WEST SUSSEX COUNTY COUNCIL CONSULTATION

TO:	Arun District Council FAO: Andrew Wood
FROM:	WSCC - Highways Authority
DATE:	3 November 2020
LOCATION:	Land adjacent to Church Farm Barn, Horsemere Green Lane, BN17 5QZ
SUBJECT:	CM/32/20/PL Change of use of land (B8 Storage) & erection of 1 No. detached single storey, two bedroom dwelling. This application affects the setting of a listed building & is a Departure from the Development Plan. This application is in CIL Zone 3 & is CIL Liable as new dwelling.
DATE OF SITE VISIT:	n/a
RECOMMENDATION:	Advice
S106 CONTRIBUTION TOTAL:	n/a

Figure 1: Proposed block plan

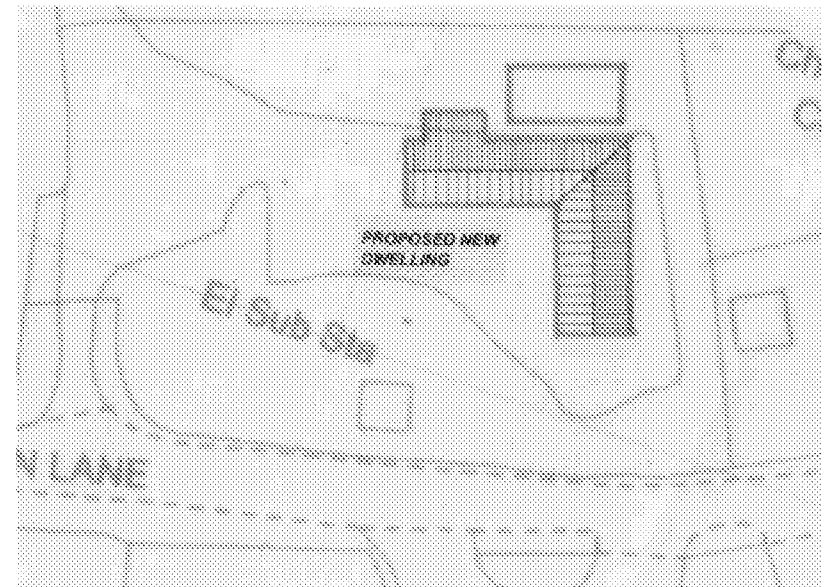
Whilst the fence is not subject of this application, the red-edge site boundary appears to demonstrate that the publicly maintained highway that has been enclosed within the fenceline is subject to this application to erect a single dwelling. As such, the applicant should be reminded of the LHA's previous comments provided for CM/36/19/PL.

Whilst the proposed fenceline does appear to obstruct visibility at the site access for the proposed dwelling; the LHA would not be able to substantiate an objection to this application on this basis as the single dwelling would not likely result in an intensification of use of the existing access over the existing B8 use. Consideration has also been given that while the previous boundary treatment was set further back than the now erected fence, the previous boundary treatment would have also had a fairly significant impact limiting visibility.

Under Arun Parking Standards (adopted January 2020), the LHA would anticipate that 2 parking spaces would be sufficient for a dwelling of this size and location. The application form indicates that the dwelling will be provided with two parking spaces, although no details have been provided on the proposed plans. Details of parking provision can be secured via condition. Each parking space must meet minimum specifications of 2.4 x 4.8m as set out in Manual for Streets.

The Design and Access statement sets out that cycle storage will be provided for the proposed dwelling. No details have been demonstrated on the plan. Details of secure and covered cycle storage can also be secured via condition.

No part of the development shall be first occupied until the car parking spaces have been constructed in accordance with plans and details to be submitted to and approved in writing by the Local Planning Authority. These spaces shall thereafter be retained at all times for their designated purpose.

No part of the development shall be first occupied until covered and secure cycle parking spaces have been provided in accordance with plans and details to be submitted to and approved by the Local Planning Authority.
